Subject: **Request for Permit Modification** for TIP No. U-2404 A, Catawba
County, Newton/Conover Loop; State Project No. 8.1792401; Federal Aid
Project No. MA-STP-16(2), Division 12.

Reference: Individual Permit, USACE Action ID No. 200331233, issued on
December 4, 2003. Major Certification, DWQ Project No. 031048, issued
on October 8, 2003.

The U.S. Army Corps of Engineers (USACE) issued a Section 404 Individual Permit (IP) to the North Carolina Department of Transportation (NCDOT) on December 4, 2003 for construction of the Newton-Conover Eastern Loop, from NC Highway 16 north to SR 1739 (Emanuel Church Road) east of Newton, Catawba County. The purpose of this letter is to request a modification of Permit Site Nos. 1, 3, & 5.

SITE #5

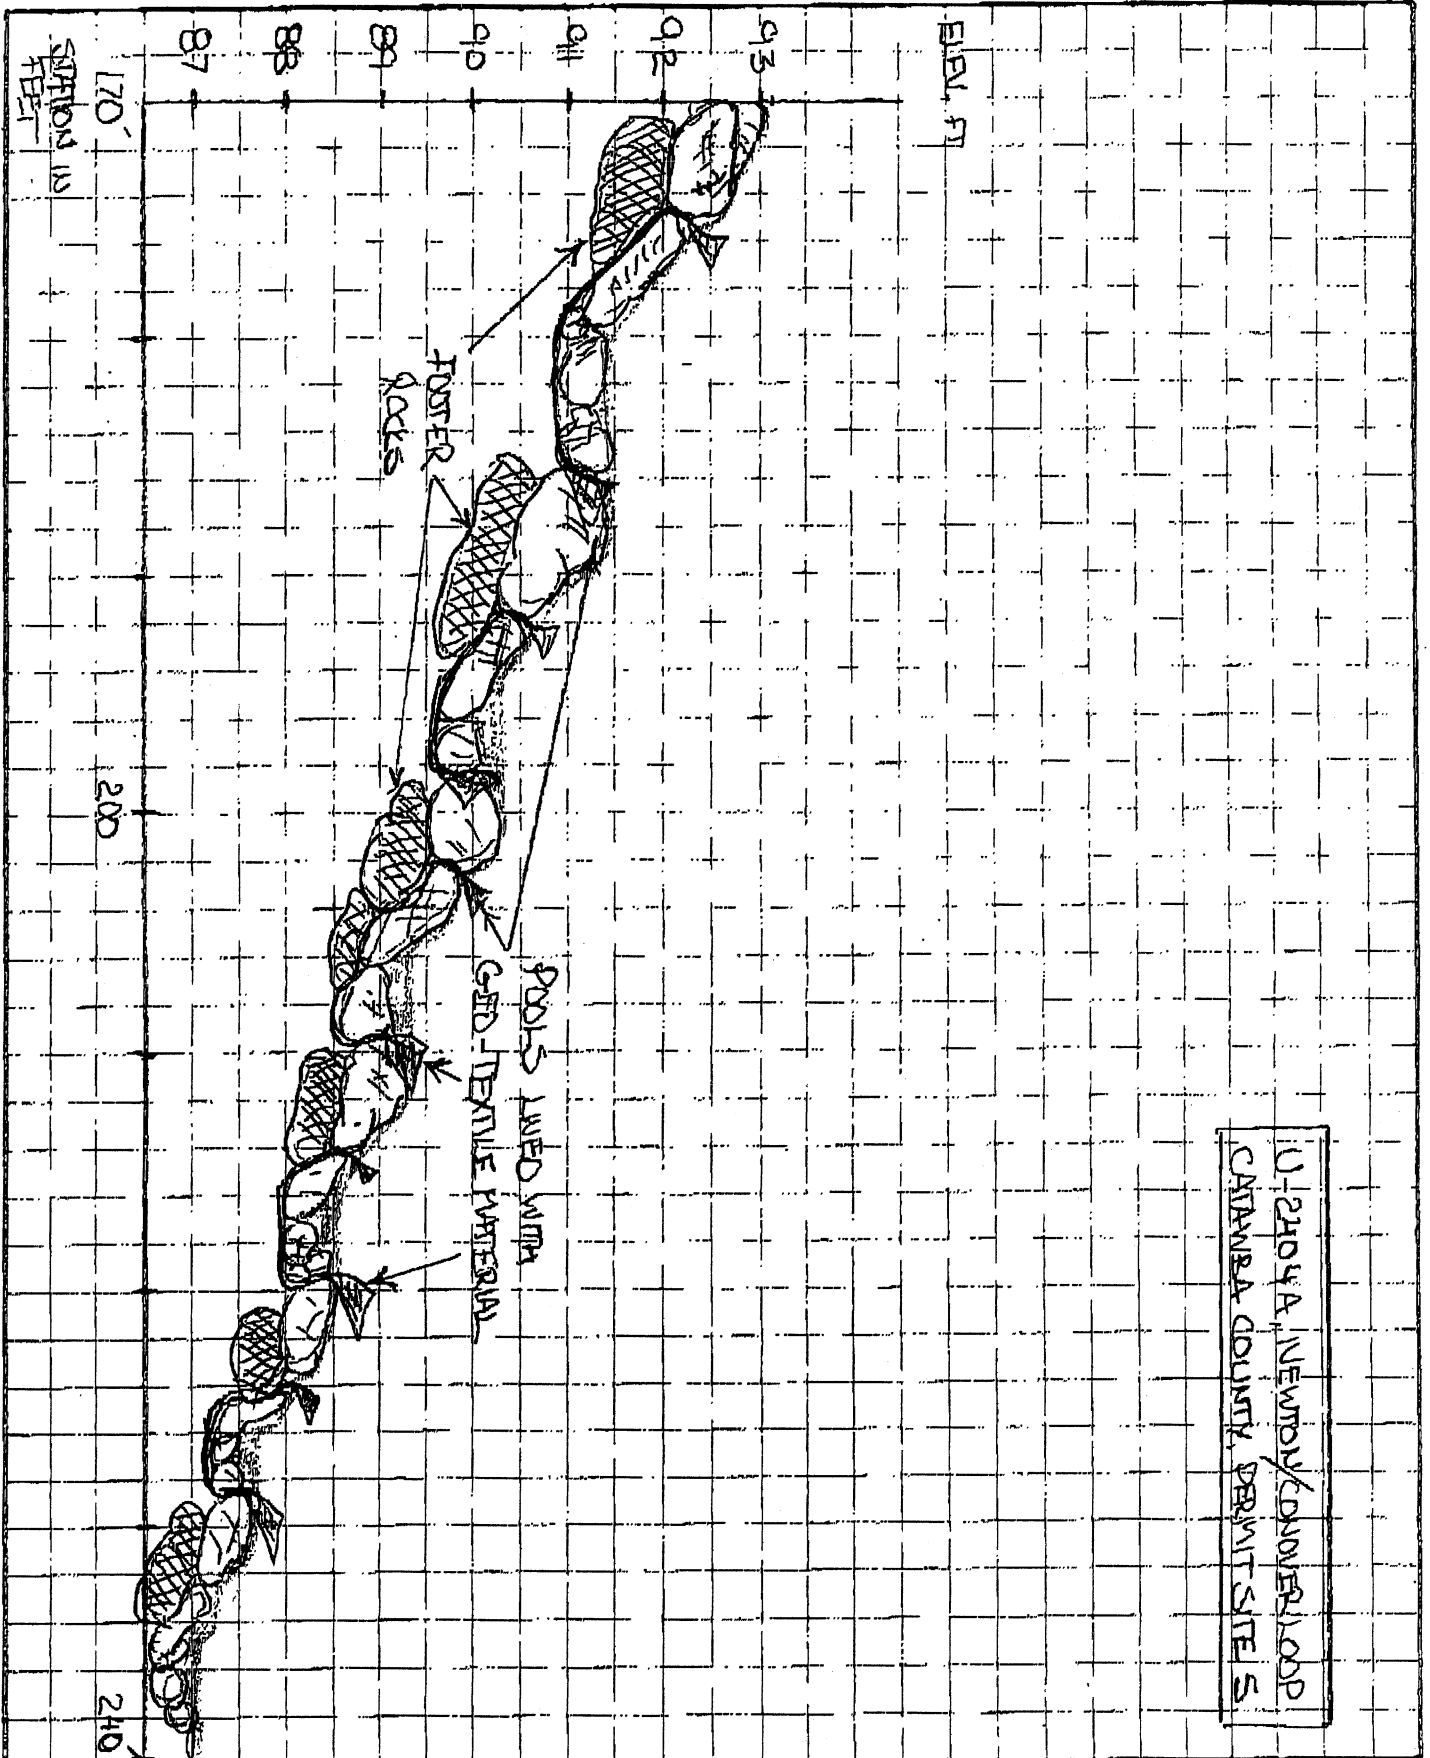
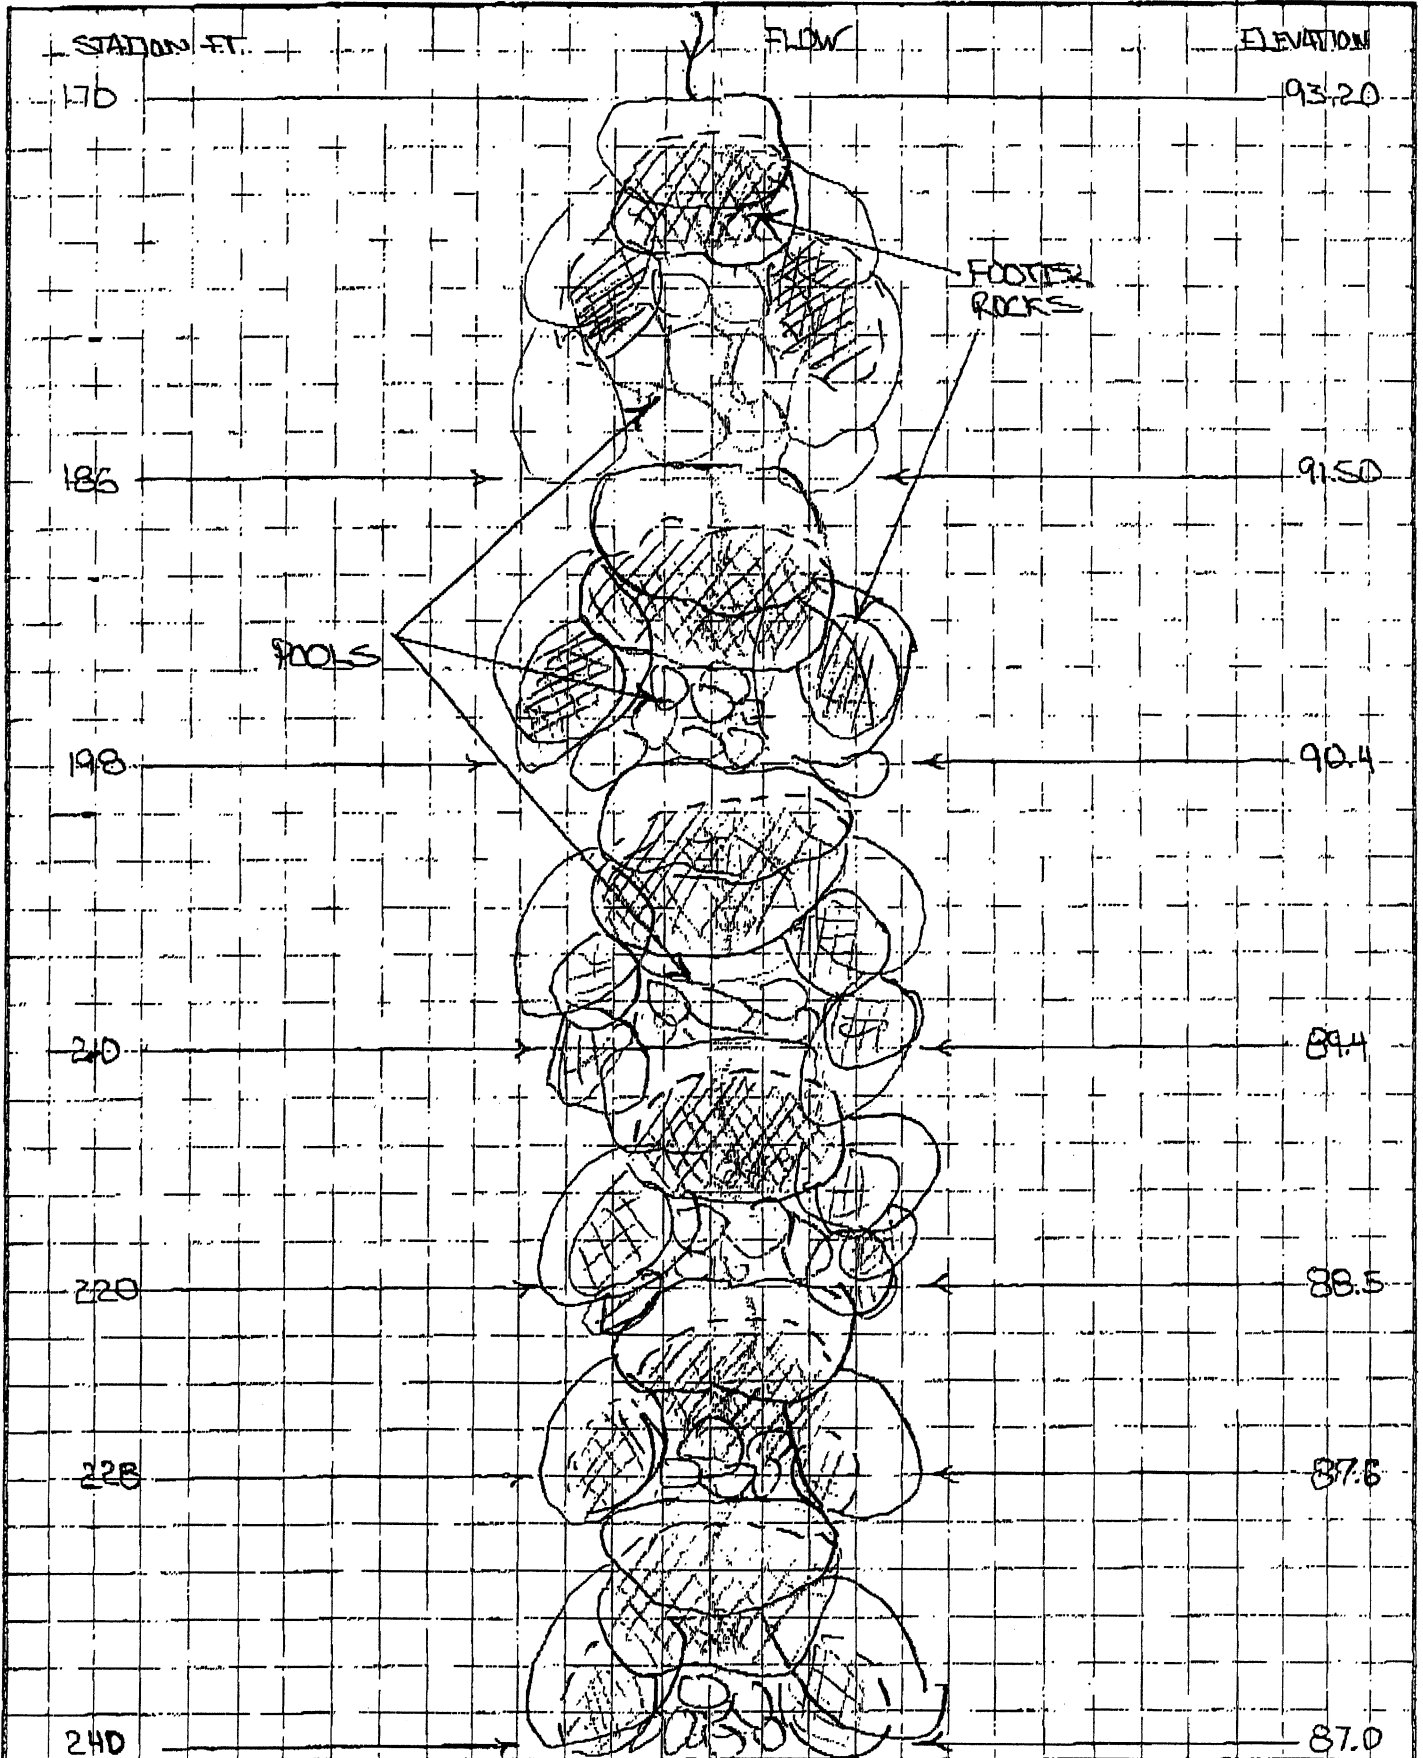
Permit Site No. 5 is located at the headwaters of an unnamed tributary to McLin Creek. The area originally consisted of two ponds in a series which were fed by springs, seeps, and storm water runoff. During construction of the subject road project, one pond was filled and the second pond is currently being used as a sediment basin. Plans indicate (see attached construction plan sheet number 13) that after construction the remaining pond is to be "graded to drain," however, the original streambed below the existing pond is incised with eroding stream banks. It is anticipated that upon project completion, and removal of the existing pond, that the stream will head cut due to soil type and additional storm flow from the road project. It is therefore proposed that rock cross vanes be

installed to act as grade control and coconut fiber matting be used to stabilize the stream banks.

The stream length, from end of pipe to edge of temporary drainage easement is 240 feet. The change in elevation is 7.8 feet, which puts the stream slope at 3.2%. It is proposed that the cross vanes be constructed in accordance with Rosgen's principles of stream morphology. There is natural rock of the appropriate size and quantity available on site for the construction of the vanes.

PLAN VIEW

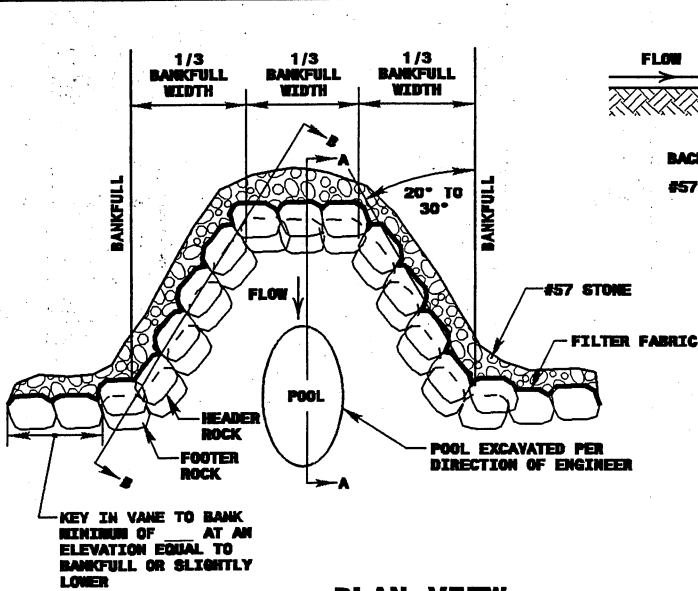
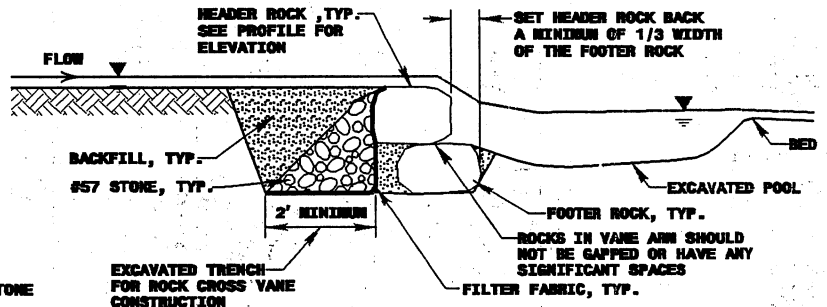
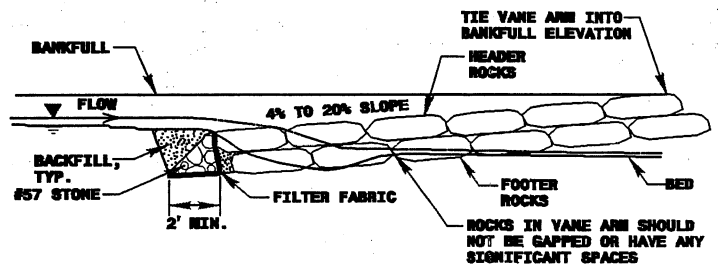
During a 401 Permit Compliance Inspection conducted by DWQ on December 13 & 17, 2004, it was requested that rock cross vanes be installed at Permit Site Nos. 1 & 3. The cross vanes are to be used for grade control to stop head cutting.

MATCH LINE -L- STA. 13+00 SHEET 4

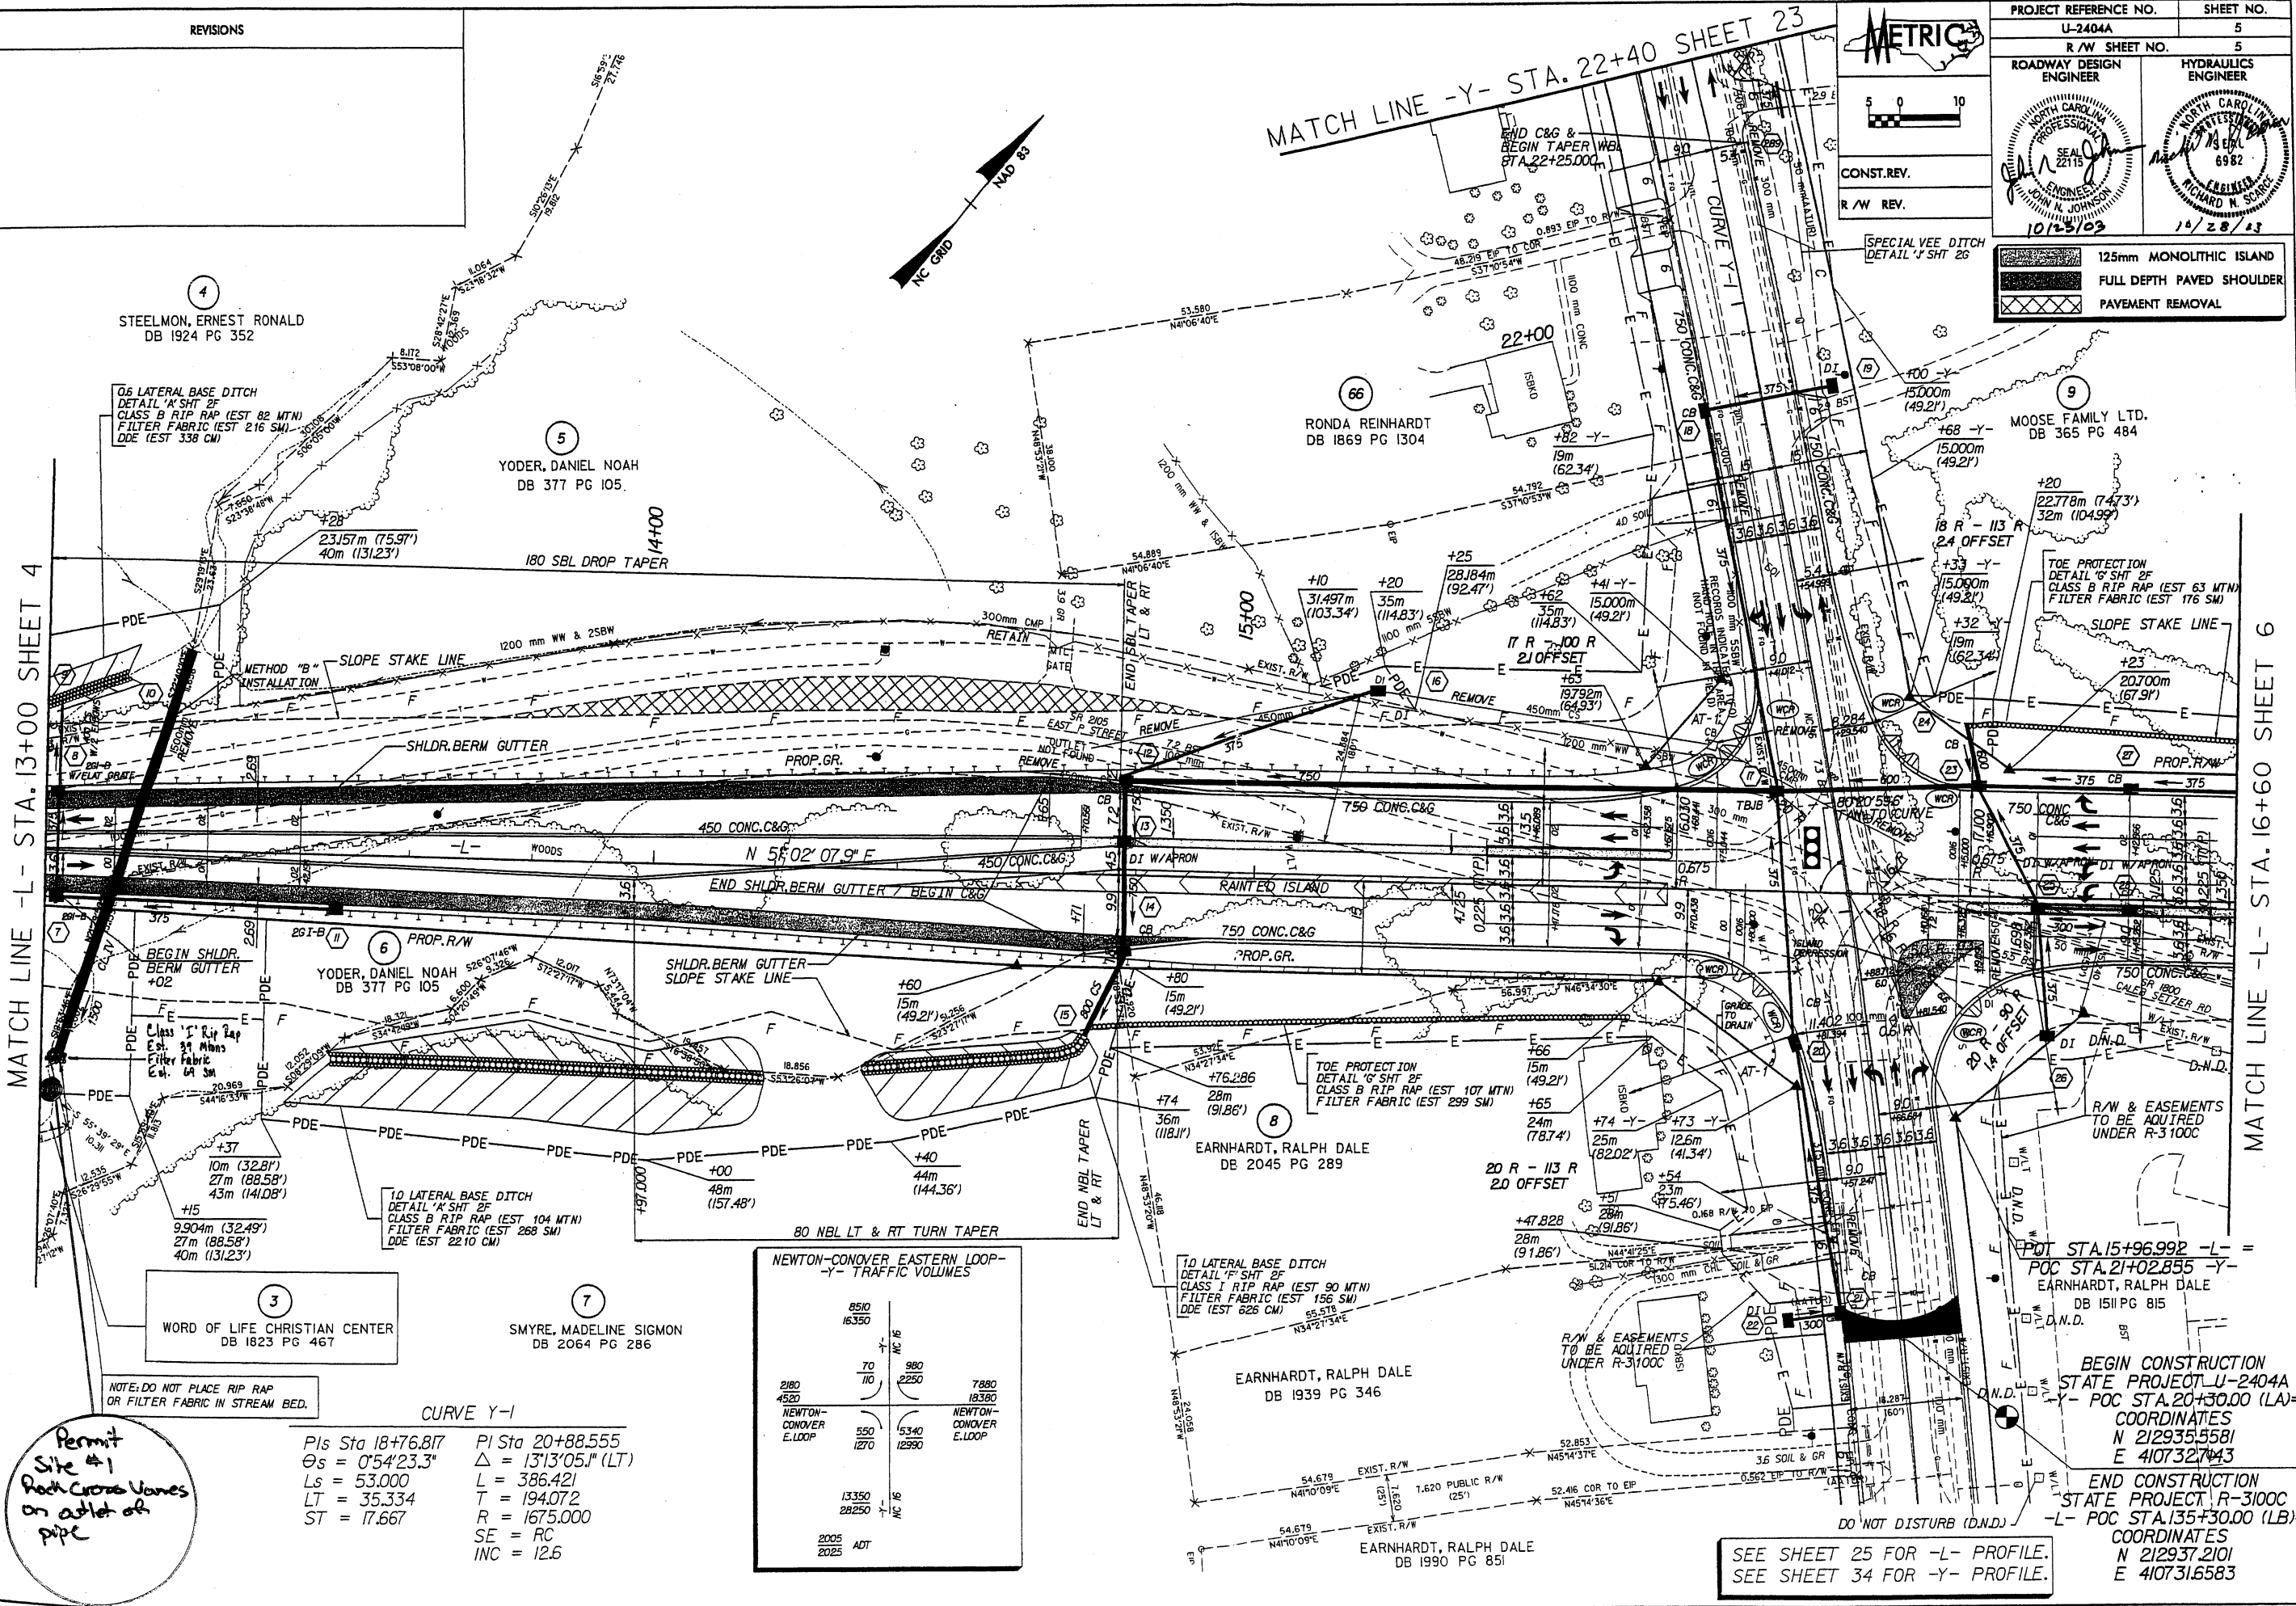
At Permit Site No. 1 it appears that rip-rap has fallen into the stream from the bank armoring the outlet end of the pipe. There is an approximate one foot grade change from the end of the pipe to a hard bend approximately 20 feet downstream which is creating the head-cut.
